**In reply please quote:** 19/29449  
**Your reference:** SSI-9364

Transport Assessments  
Department of Planning, Industry and Environment  
4 Parramatta Square  
PARRAMATTA 2150

## **M12 ENVIRONMENTAL IMPACT STATEMENT (EIS) – MAJOR INFRASTRUCTURE PROJECT**

Figure 2-1 Key features of the amended project

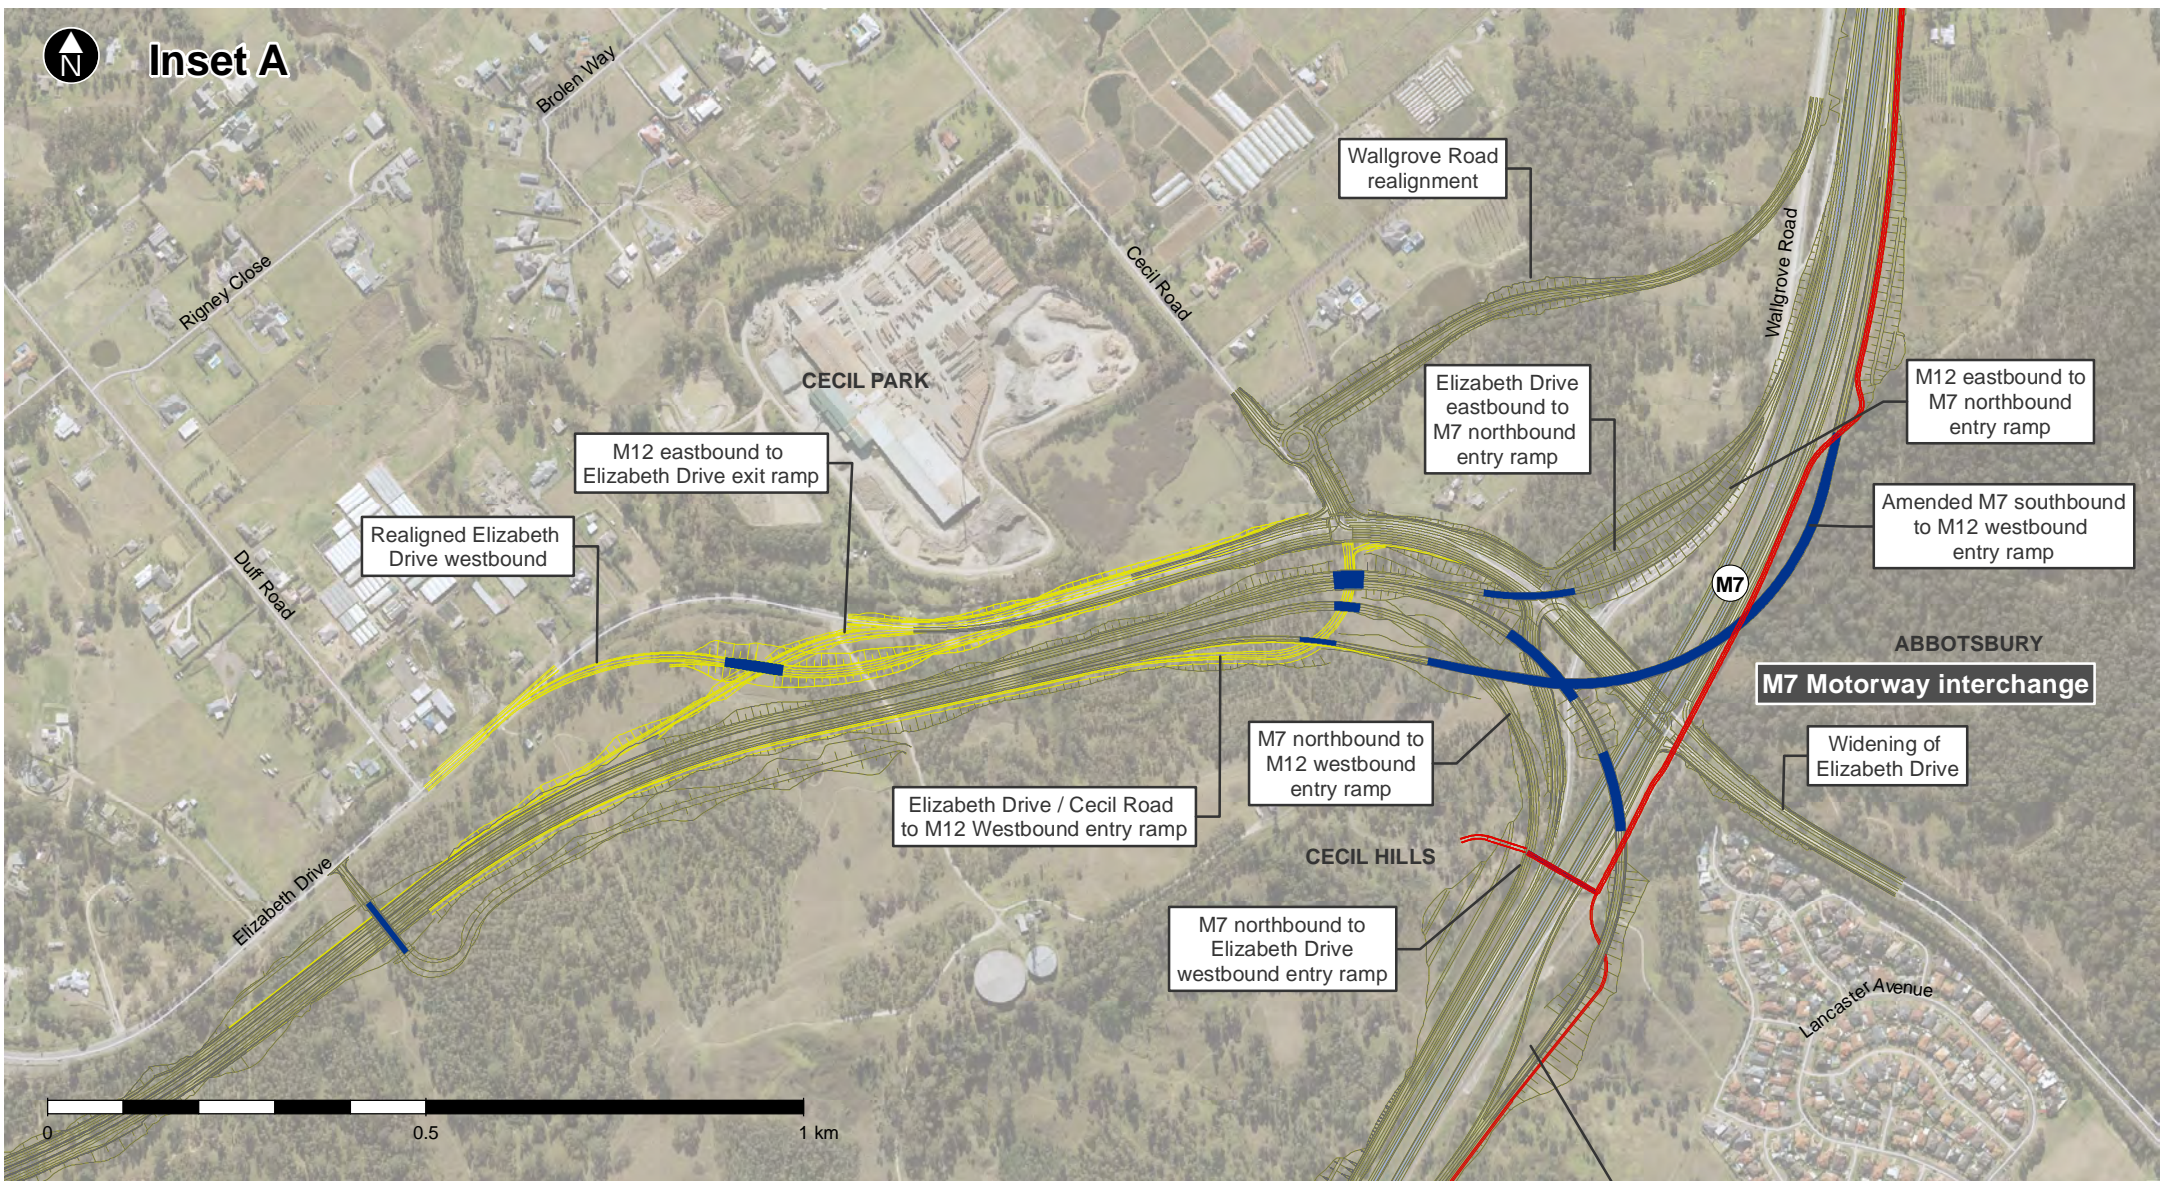
Under both Options 1 and 2 Council strongly recommends that TfNSW undertake further investigations and analysis of the proposed new roundabout at the intersection of Wallgrove Rd and Cecil Rd and new signalised intersection of Cecil Rd and Elizabeth Drive. Under the current amended design there would appear to insufficient distance between the two intersections to allow for queuing of traffic that could undermine the performance and traffic safety levels of the intersections and associated road network.

- While Option 2 is preferred, what is not clear is the expected diversion of traffic onto the local road network with this option i.e. proceeding straight onto Cecil Road instead of turning right into Wallgrove Rd.

- The traffic model needs to be amended to assess the impact on the local road and what actions need to occur to address these impacts with the advent of the M12 (the traffic model was not amended to accurately reflect the Wallgrove Road deviation across to Cecil Road).

- Council suggests that the road corridor needs to be sized now to accommodate future upgrade to traffic control signals at the new Cecil Road/Wallgrove Road intersection i.e. land acquired as part of the project for 4 lanes plus turn bay/bus priority/cycle infrastructure.

- Under Option 2, the creation of ramps between the M12 Motorway and Elizabeth Drive, Cecil Road and Wallgrove Road is considered a baseline requirement i.e. not dependent on additional funding.

**Figure 3-3** Key differences between option 1 and option 2 of the amended project

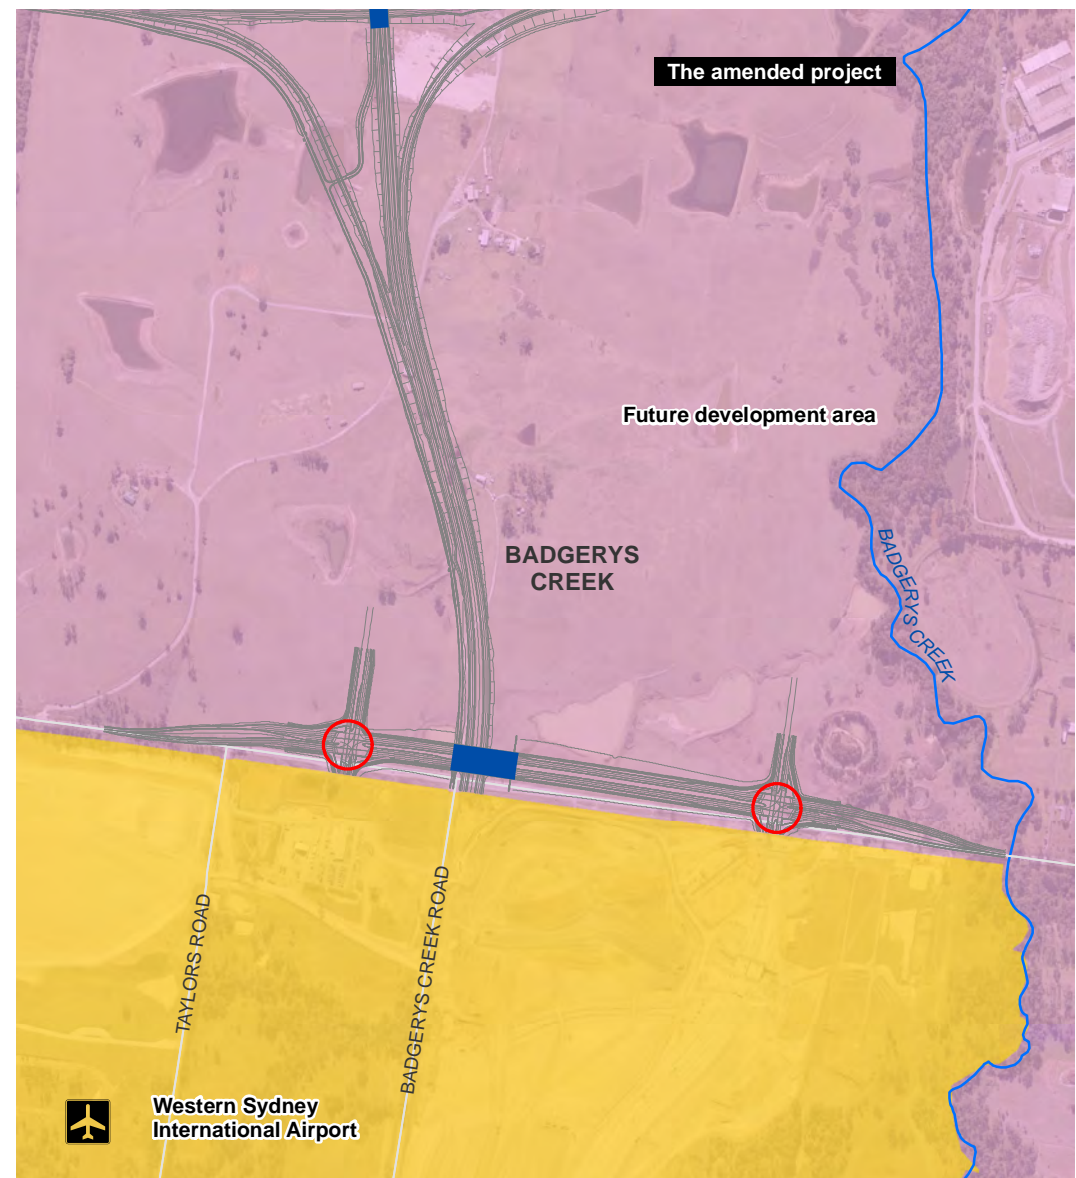
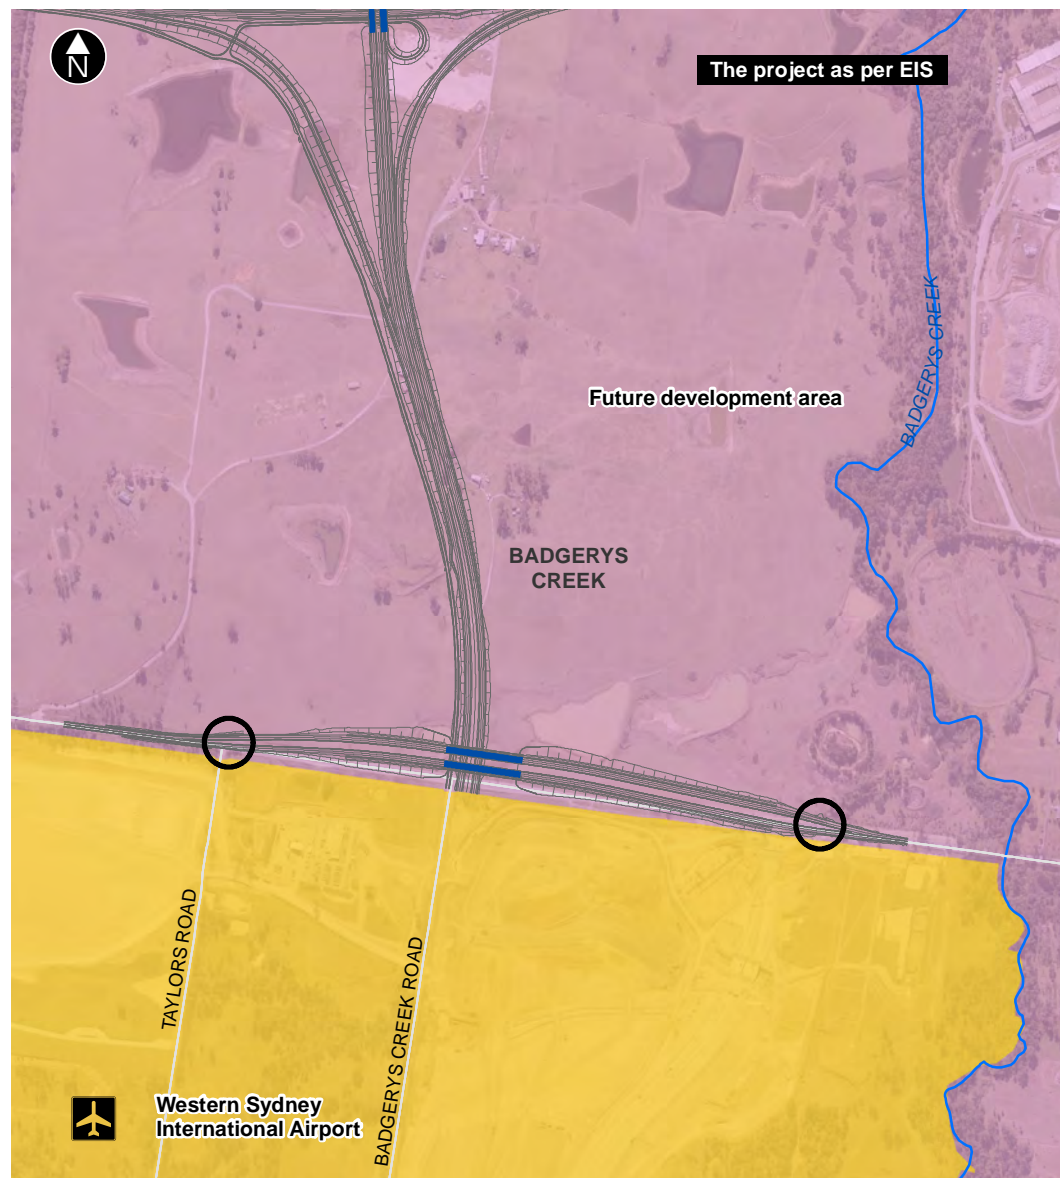
Council endorses Option 2 (above) as this provides the greatest scope for road network improvements to the broader community of the Western City by providing a toll free option (via the M12) to the Western Sydney Airport at Badgerys Creek.

Option 2 would also represent a far superior option in terms of the concerns raised by Council in regard to longer term strategic traffic planning and management issues in proximity of the M12/M7 Interchange as follows:

- The design supports the role of Cecil Rd as a primary southern access Rd to the UIA as per the draft Structure Plan endorsed by Council in April 2019.
- The changes also support the potential for establishing a future town centre (supported by rails station) that has direct access to the M12 (including direct motorway access to the WSA), as well as maintaining northbound access onto the M7.
